Our Ref: BE/6/19/HH

**Town & Country Planning Act 1990 (as amended)
Town & country Planning (Development Management Procedure) (England) Order 2015
Application for Planning Permission for Works or Extension to a Dwelling**

Development Rear Two Storey Extension.
Location 72 Sunningdale Gardens Bersted

PROPOSED GROUND FLOOR PLAN

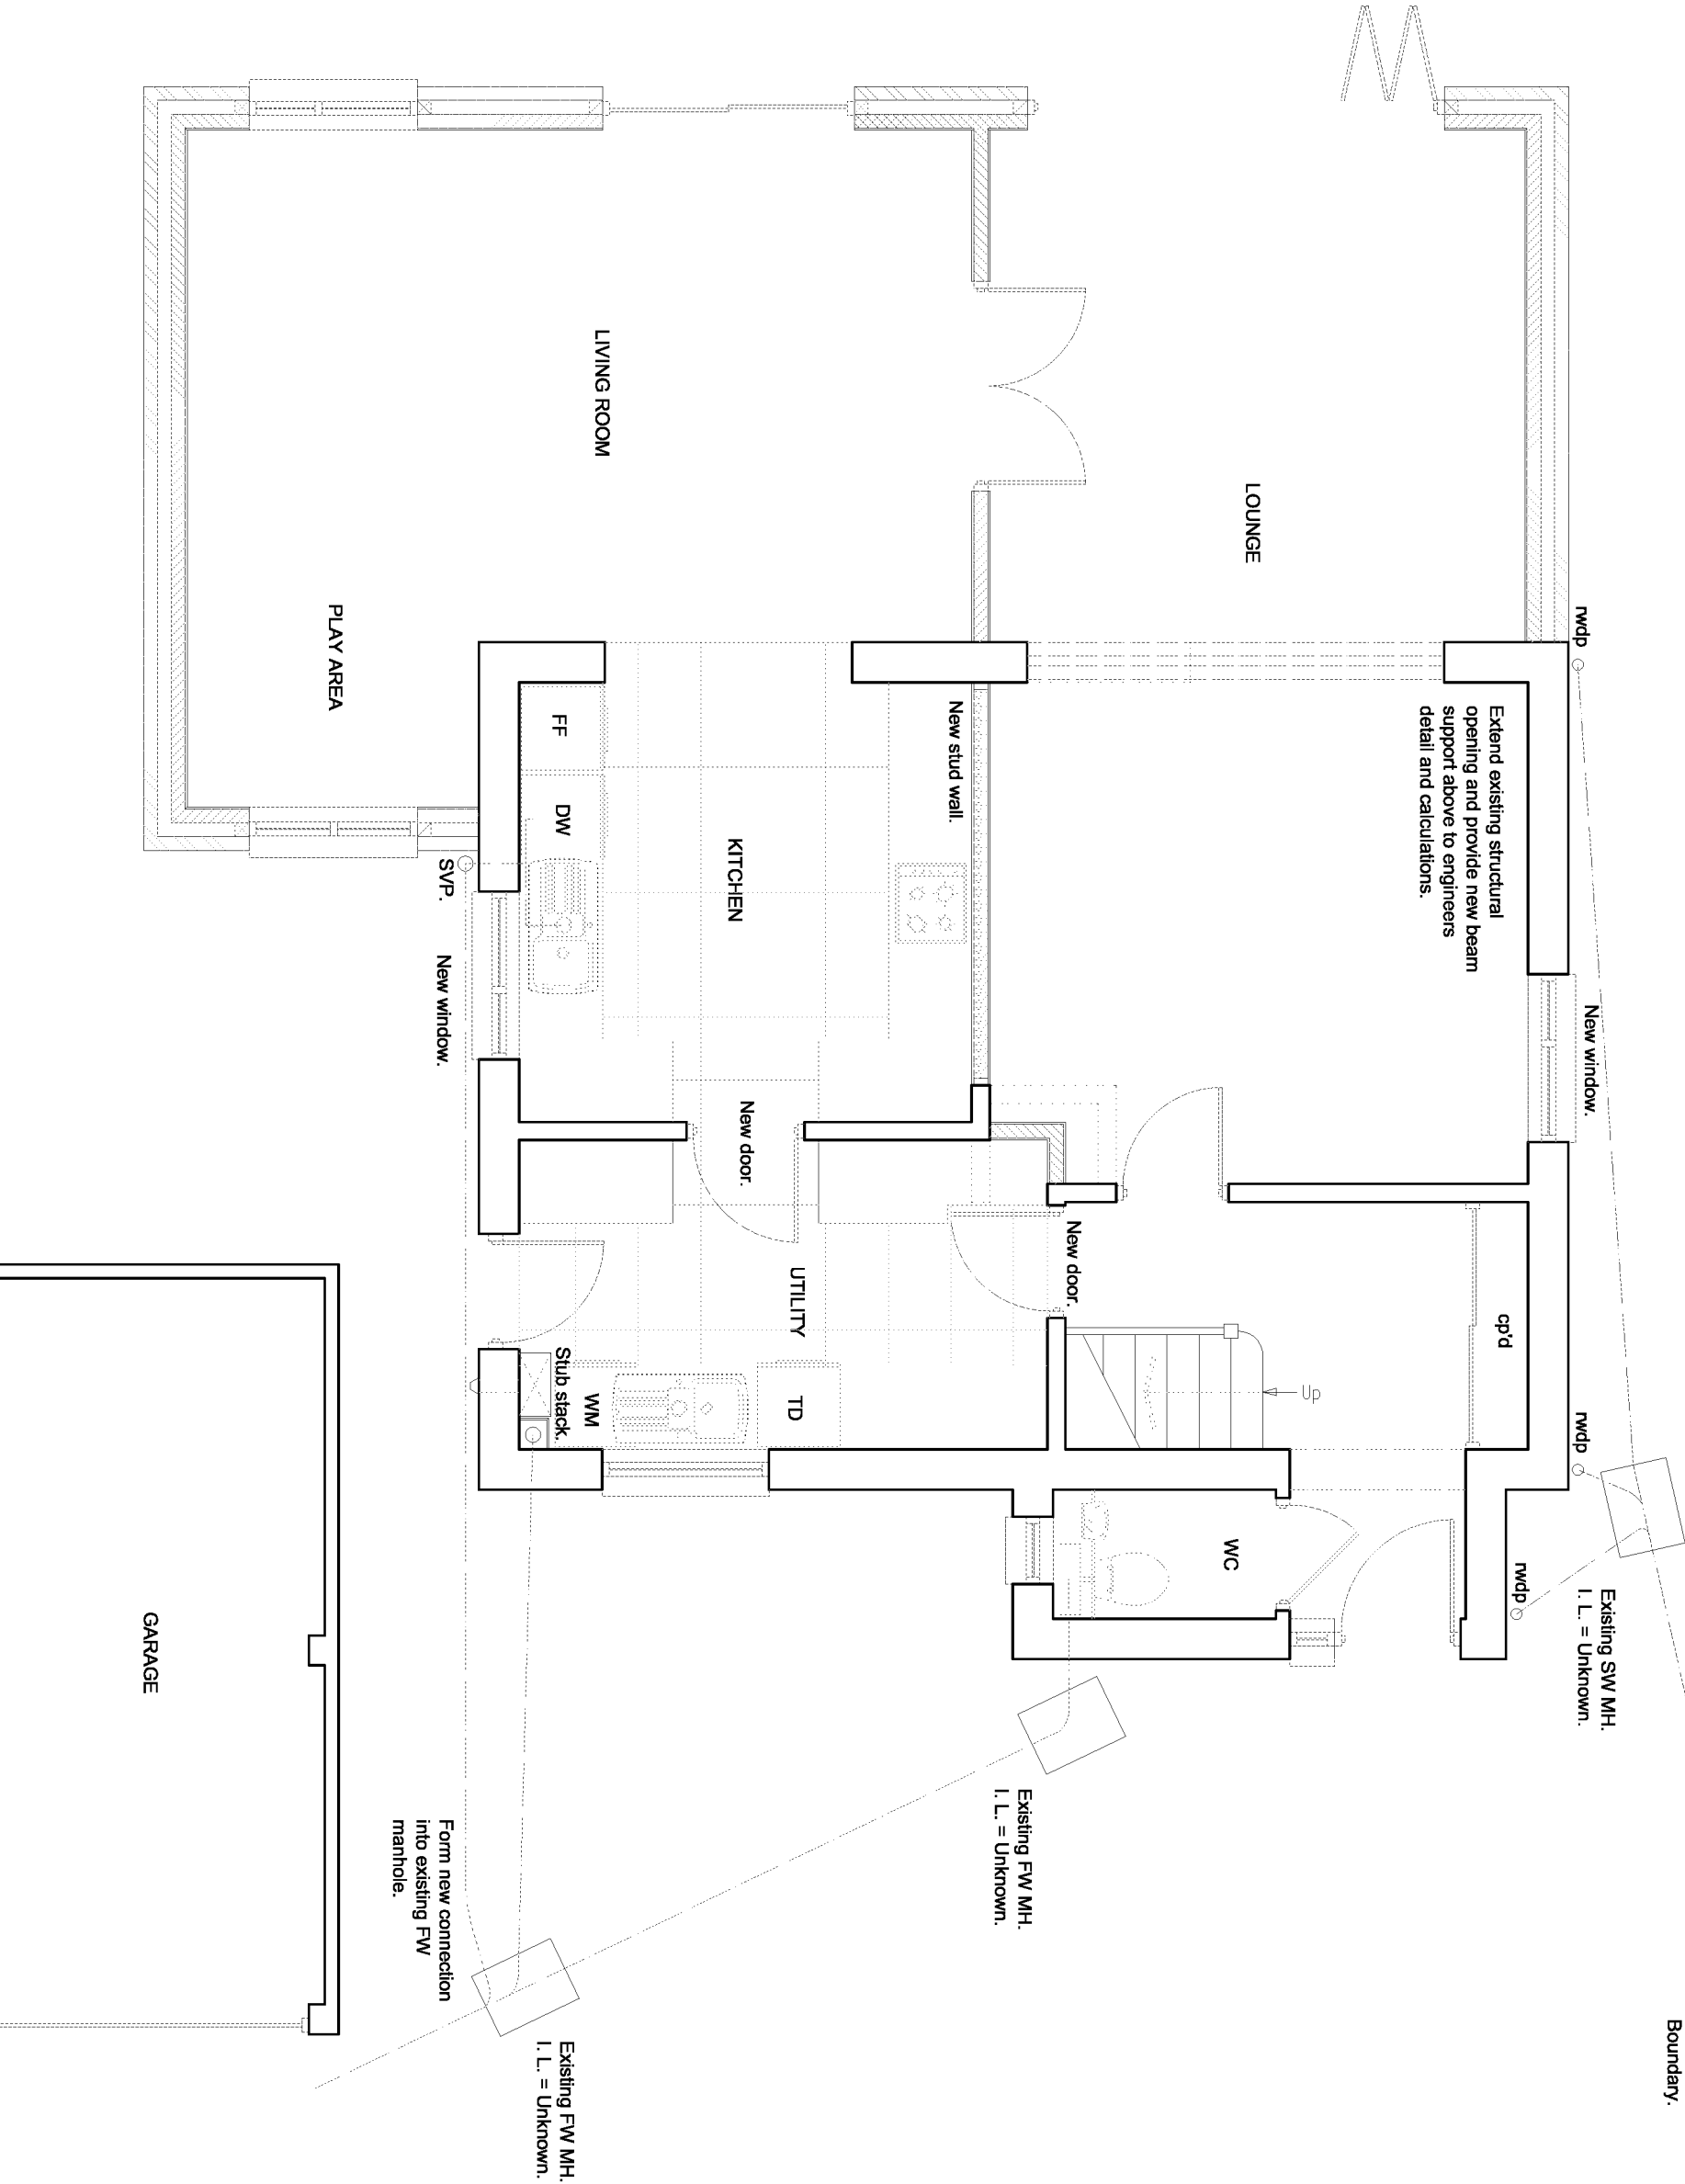
Plan Not To Scale: The ground floor plan is not too scale due to the conversion of the plan.
Please amend accordingly.
